Subdivision Comments

Date: 04/27/2023

RE: SE-23-00009 Nelson View

NELSON VIEW
SUBDIVISION

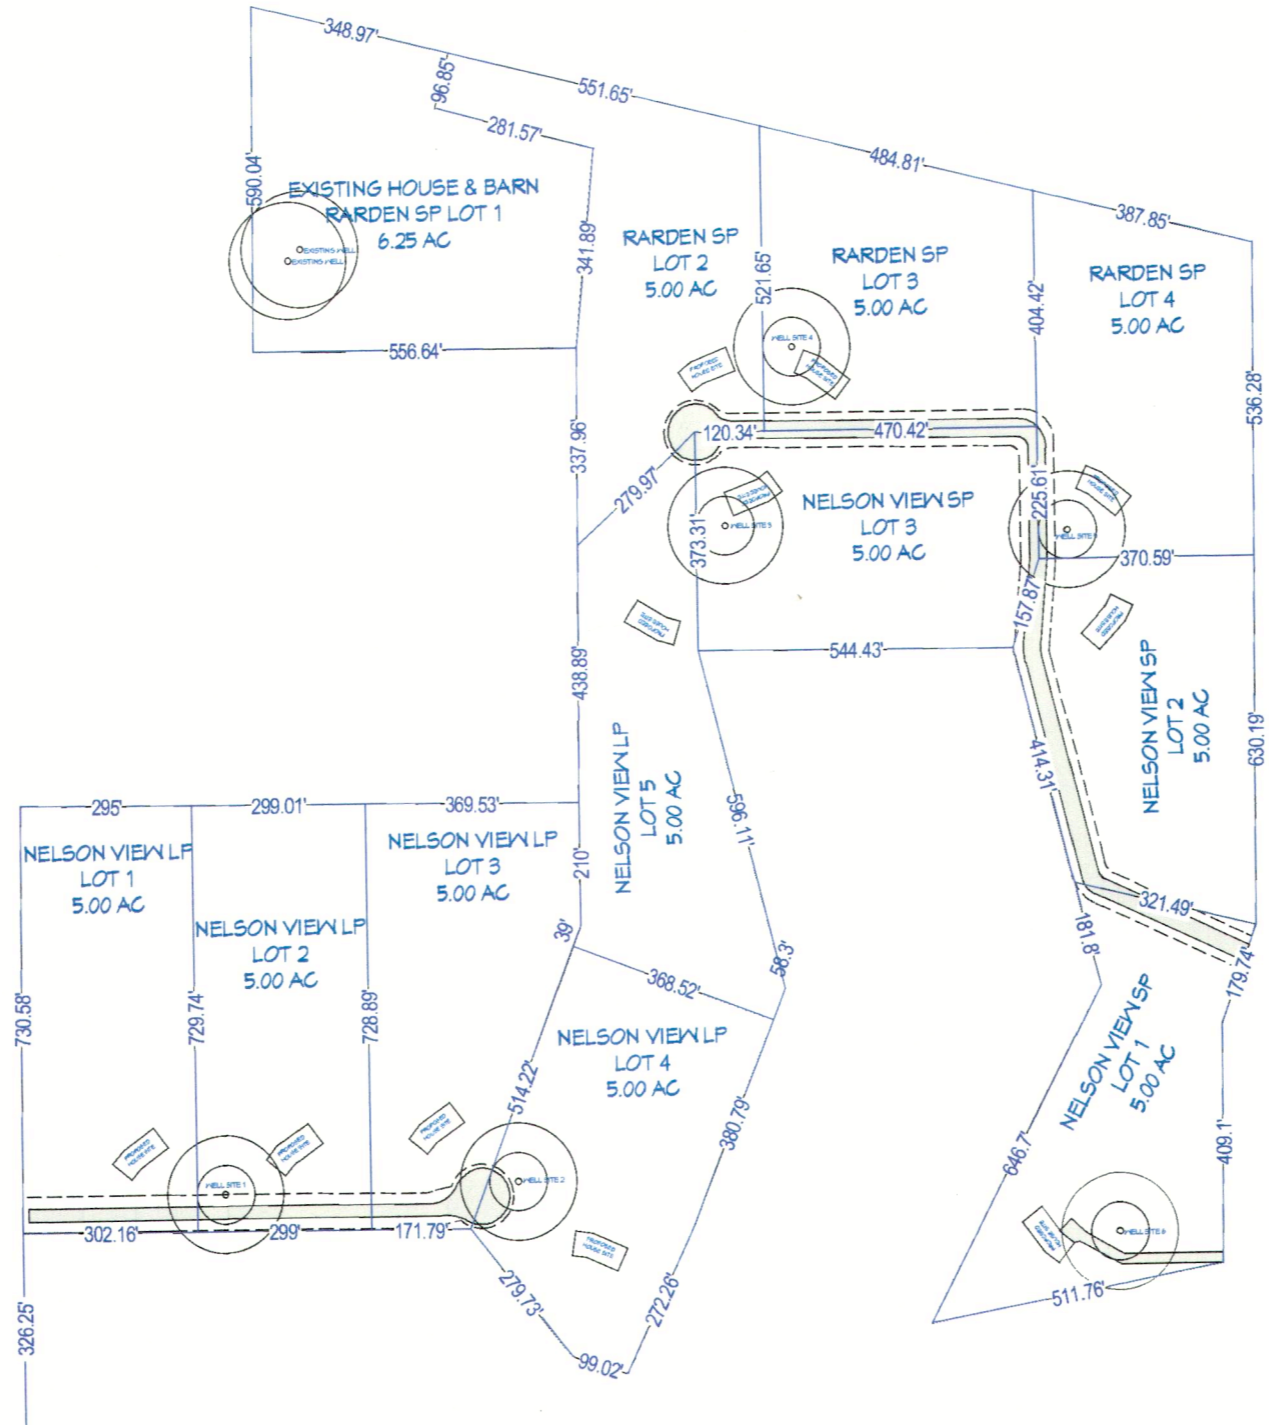
Proposed short plat shared wells will be used. If the intention is to utilize a shared well, a signed, notarized, and filed shared well users agreement will also need to be provided before the short plat is finalized. If shared wells are to be utilized, the wells must be drilled a minimum of 50 feet from any proposed property line and a signed, notarized and recorded shared waters users' agreement for each shared well must be submitted to our office prior to final plat approval. The applicant must prove physical availability of water for all new uses of water proposed lots of this project, which can be provided by (See Condition A-1) a well log or 4 hour draw down test as proof of water availability for each new well proposed. All persons who are

A soil log is needed for the proposed lots

A signed and recorded shared water user's agreement between proposed lots is needed. Along with a current water right for the proposed lots.

A-1 13.35.020(b) requires proof of adequate water supply, which can be submitted through a well log or 4 hour draw down test if an existing well is used and is older than 10 years. If shared wells are used, a signed, notarized, and recorded shared well-users agreement must be submitted. All individual and shared wells must meet the distance requirement of 50 feet from the property line, 50 feet from the septic tank and 100 feet from the drain field as per Kittitas County Critical Areas Ordinance 17A.08.25, and KCC Chapter 13.

A-2 Soil logs are required for lots. In accordance with KCC 13.04.090, a minimum of one soil log for each proposed lot where individual sewage disposal systems are contemplated must be completed prior to final plat approval. Soil logs can be scheduled at <https://www.co.kittitas.wa.us/health/septic-inspection.aspx>. Soil logs are performed in accordance with WAC 246.272A
